Project: Mars Data Centre – SSD-82052708 – 12 Mars Road, Lane Cove West

Subject: Objection to Proposed Data Centre Development in Lane Cove West

5 May 2026

1 EAST ELEVATION
1 : 500

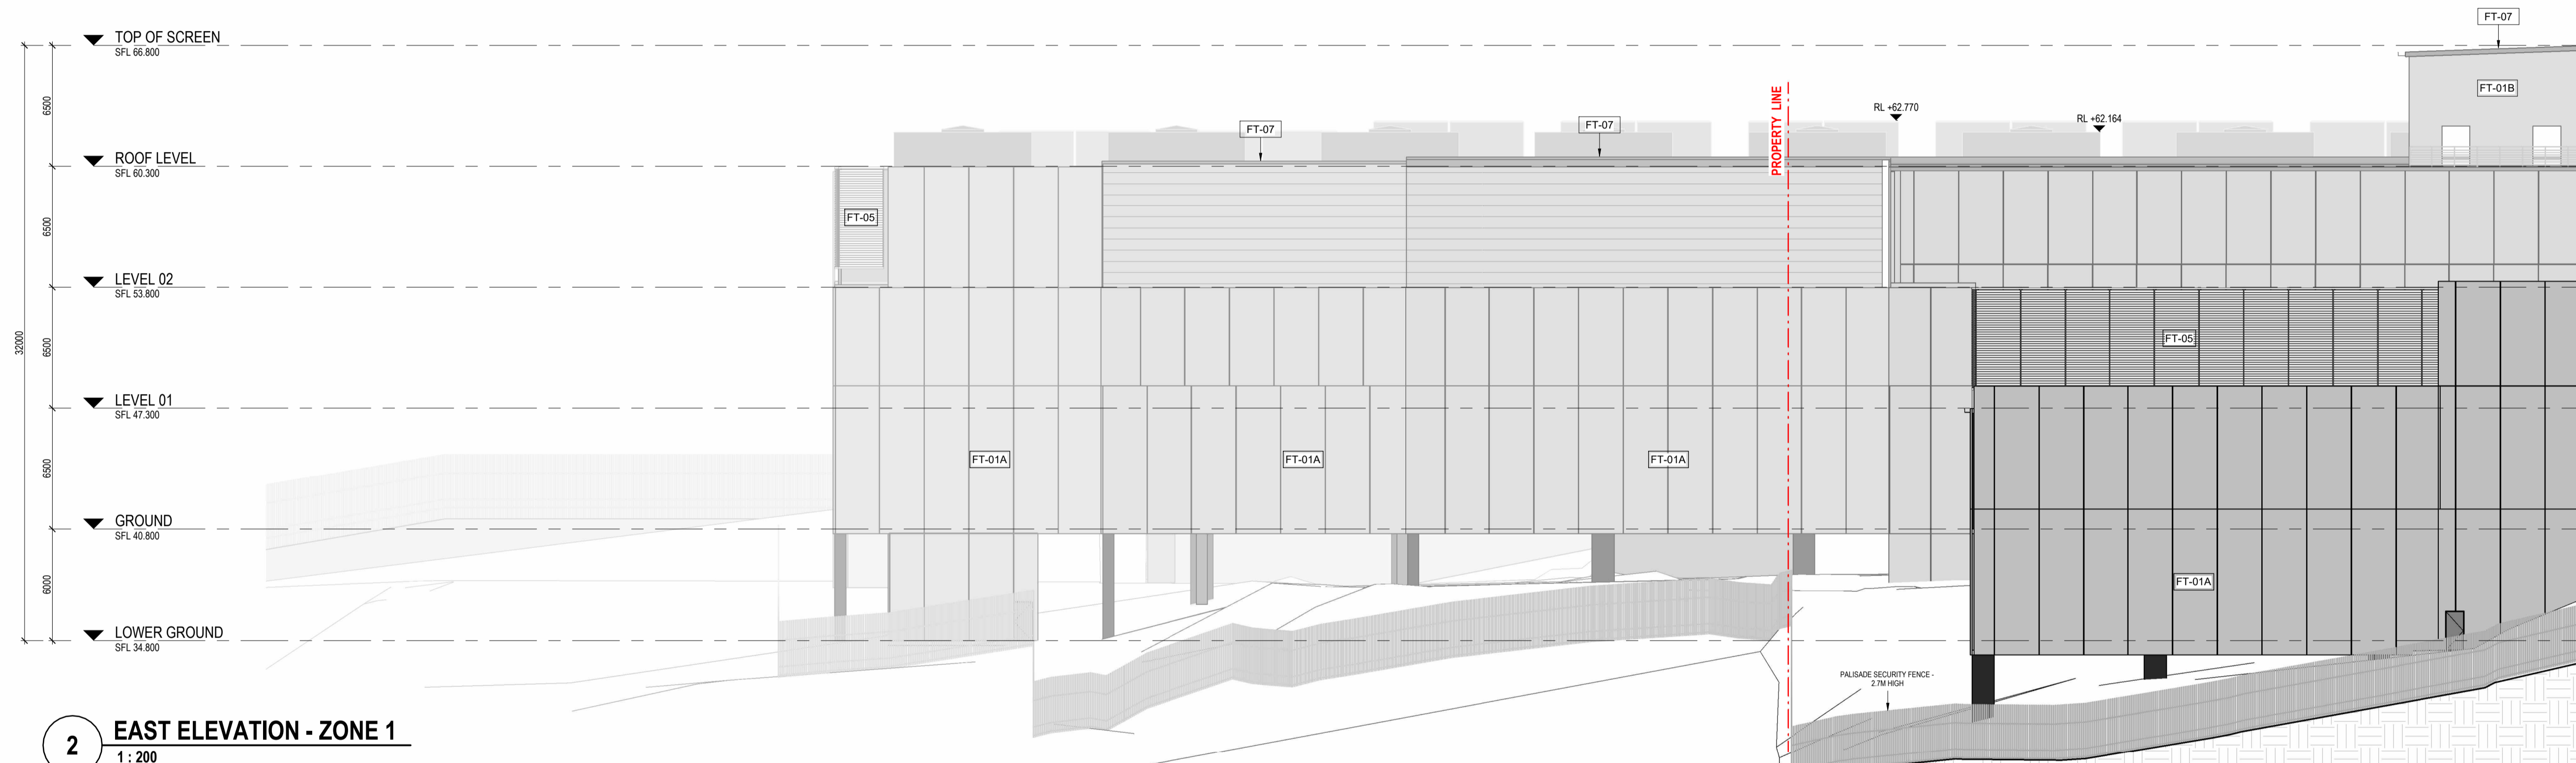
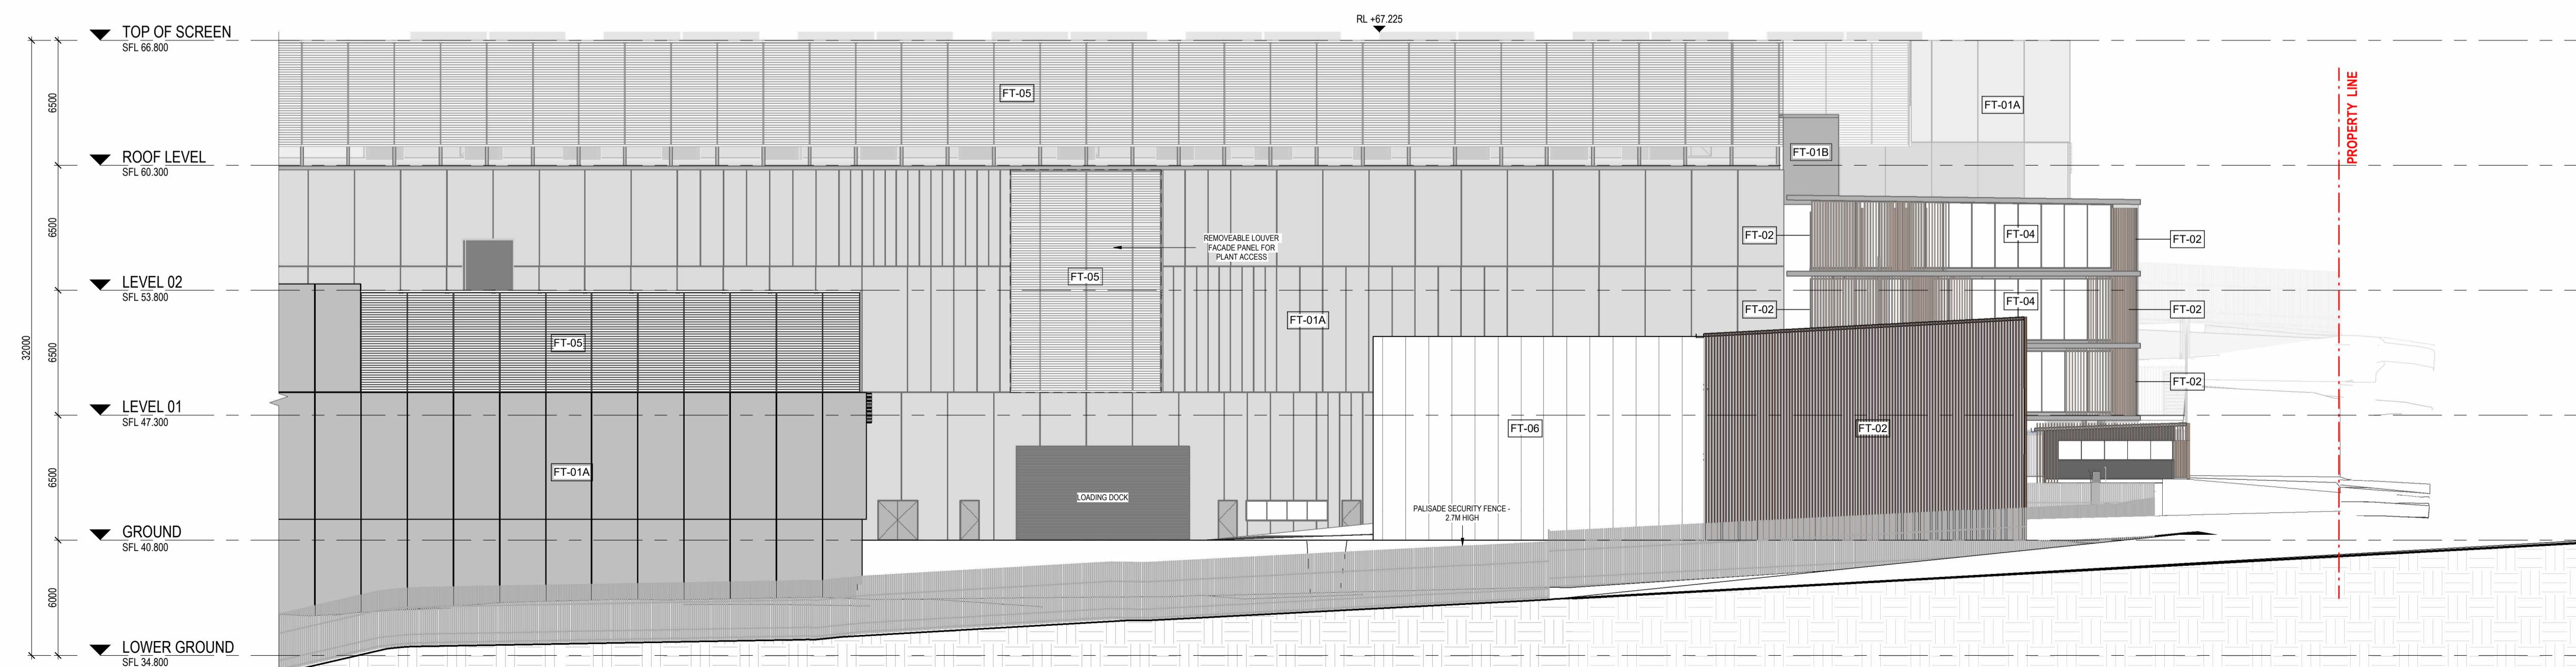
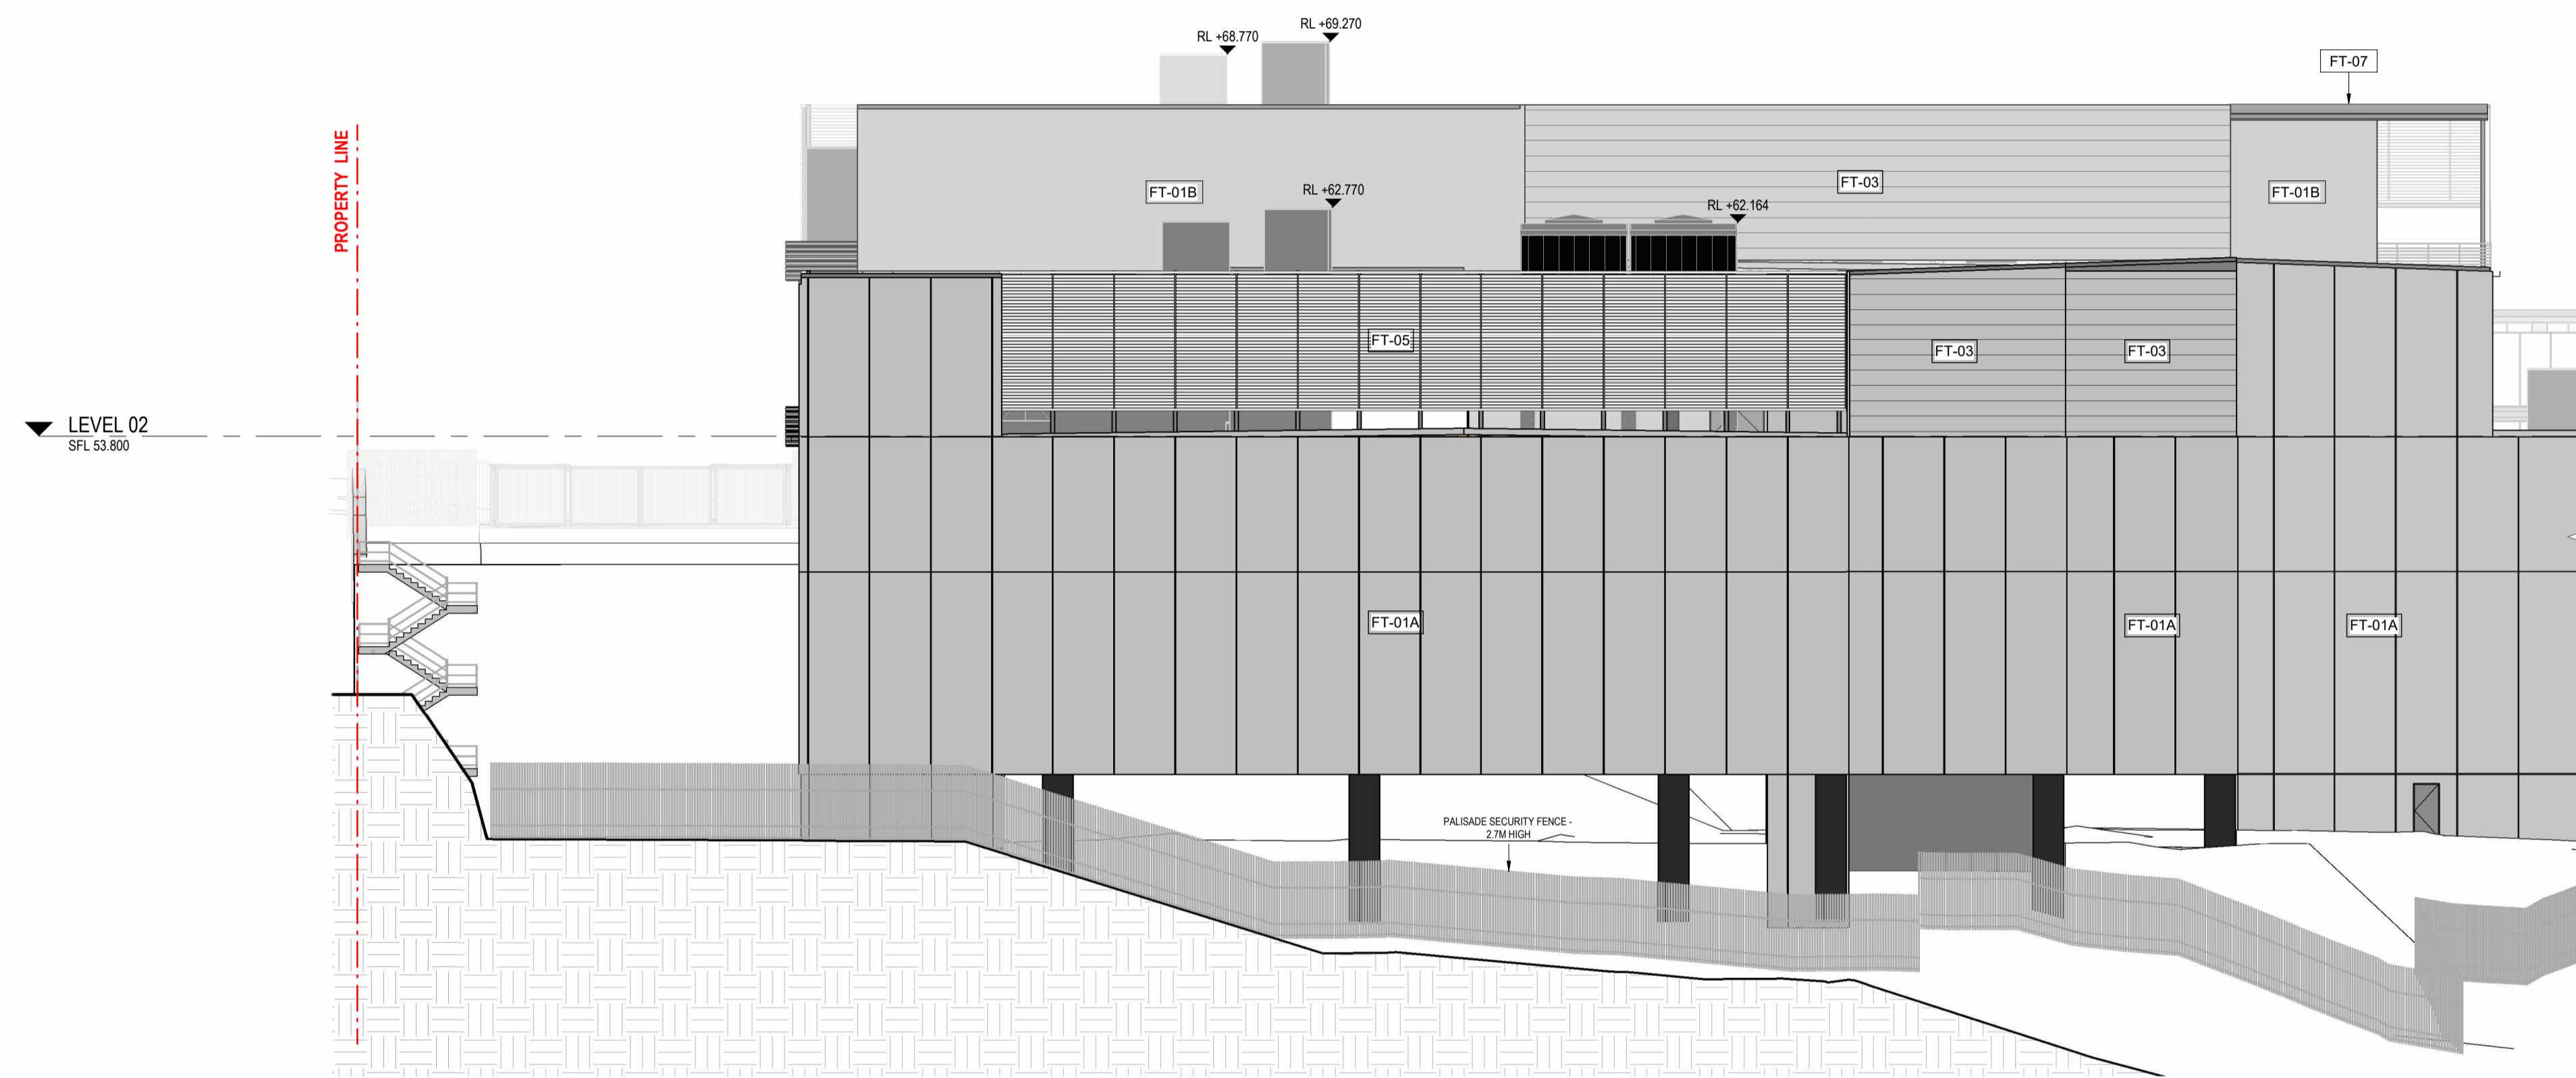
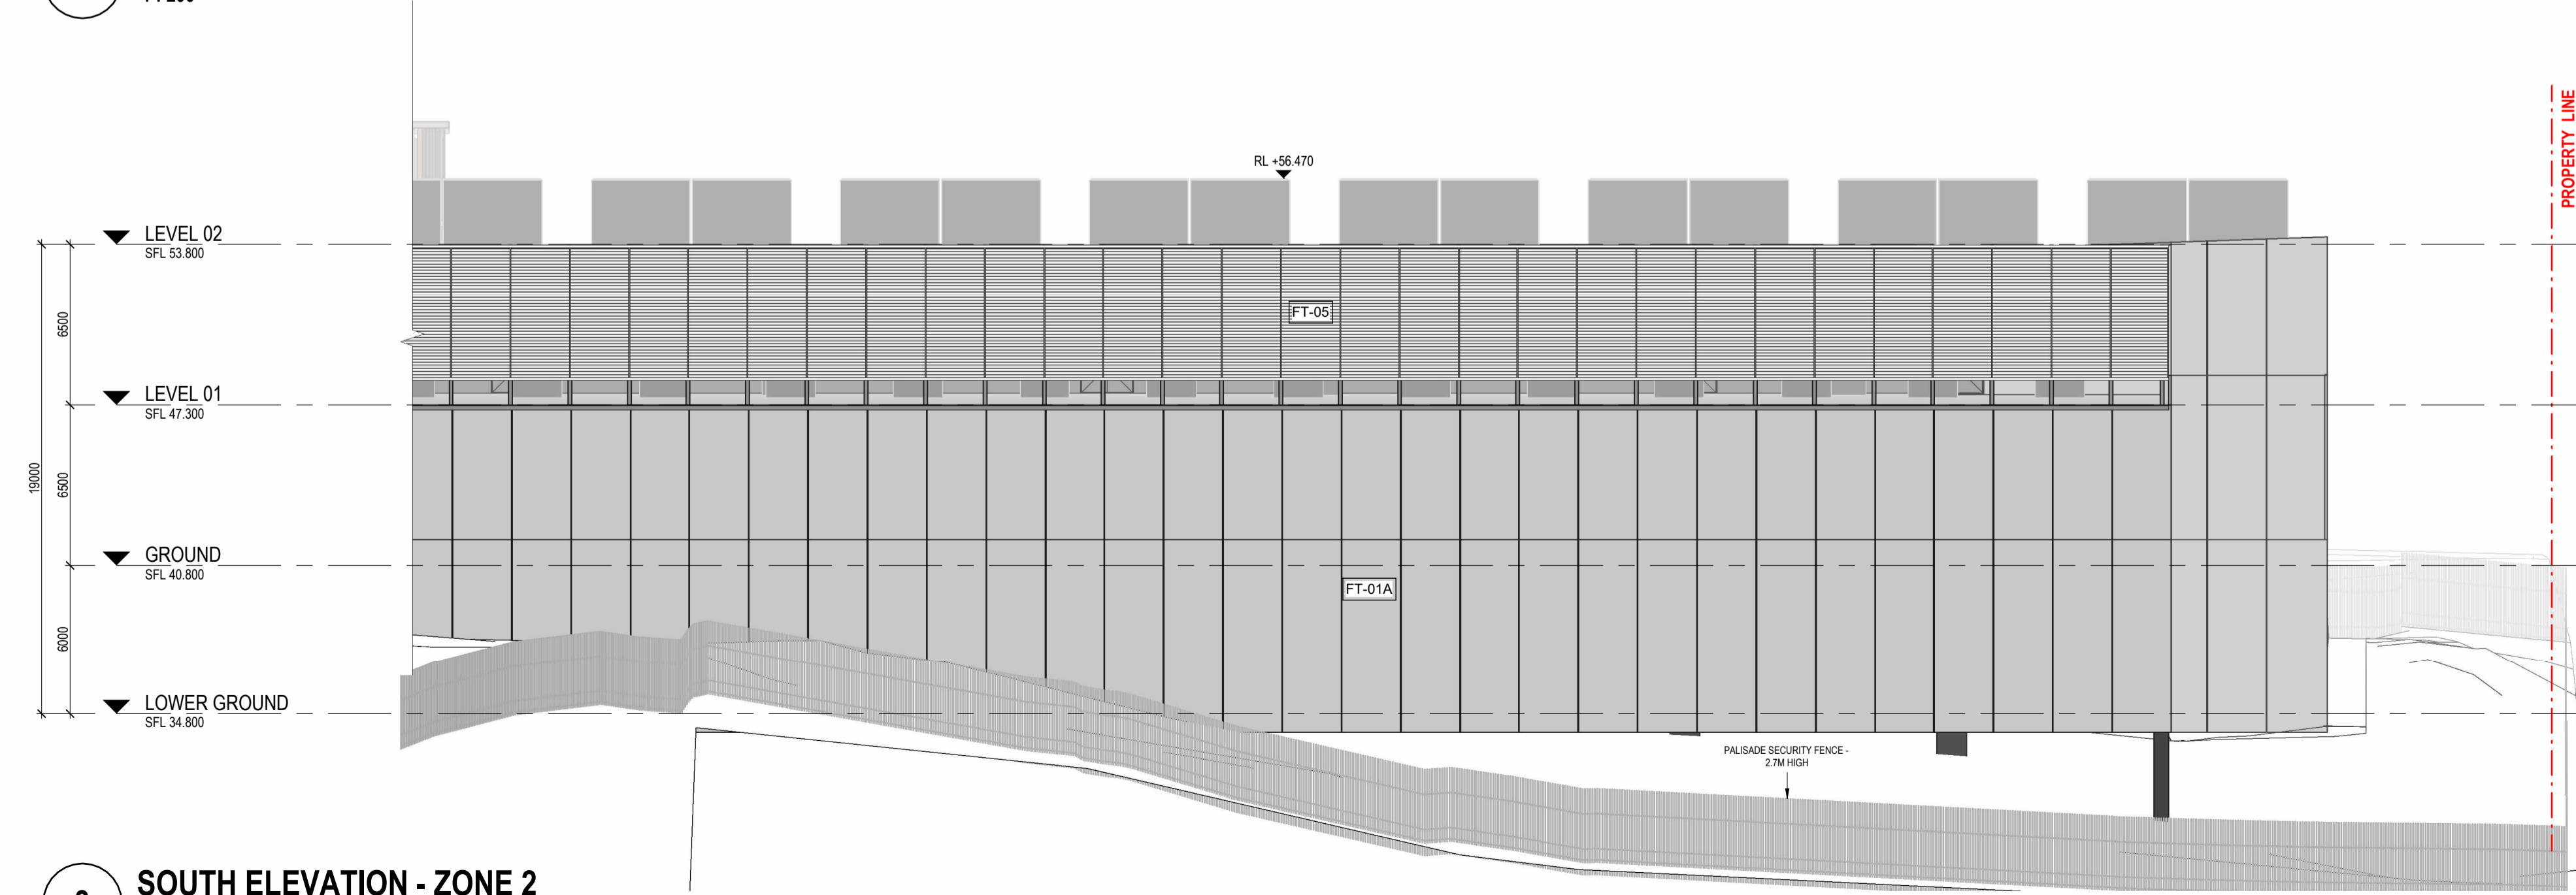
The clause 4.6 Variation Request submitted states the proposal has a maximum height of approximately 28.3 m, which represents a maximum height variation of 10.3m (57.2%) compared to the maximum height of building control of 18 m set out within the Lane Cove LEP 2009.

Whilst this 57.2% breach to the development standard is outrageous on face value, it also significantly understates the perception of the bulk and scale of the building at adjacent sensitive community and residential uses. The site falls away towards east and south where the sensitive uses are located. Therefore, the perception of overbearing height and scale is amplified at the sensitive uses by virtue of these being located downhill from the development.

- Adequacy transition built form down to the sensitive community and residential uses to the east and south. The Variation Request states the proposal will be taller than existing industrial uses in the Lane Cove West Business park, which being the closest site to sensitive uses, is the exact opposite of what good urban design requires. The applicant should not only be required to comply with the DCP height limit, but also include further stepping down towards the eastern and southern boundary adjacent residences. The proposal should be required to be no higher than existing established trees when viewed from multiple locations along Lloyd Rees Drive and Wood Street.
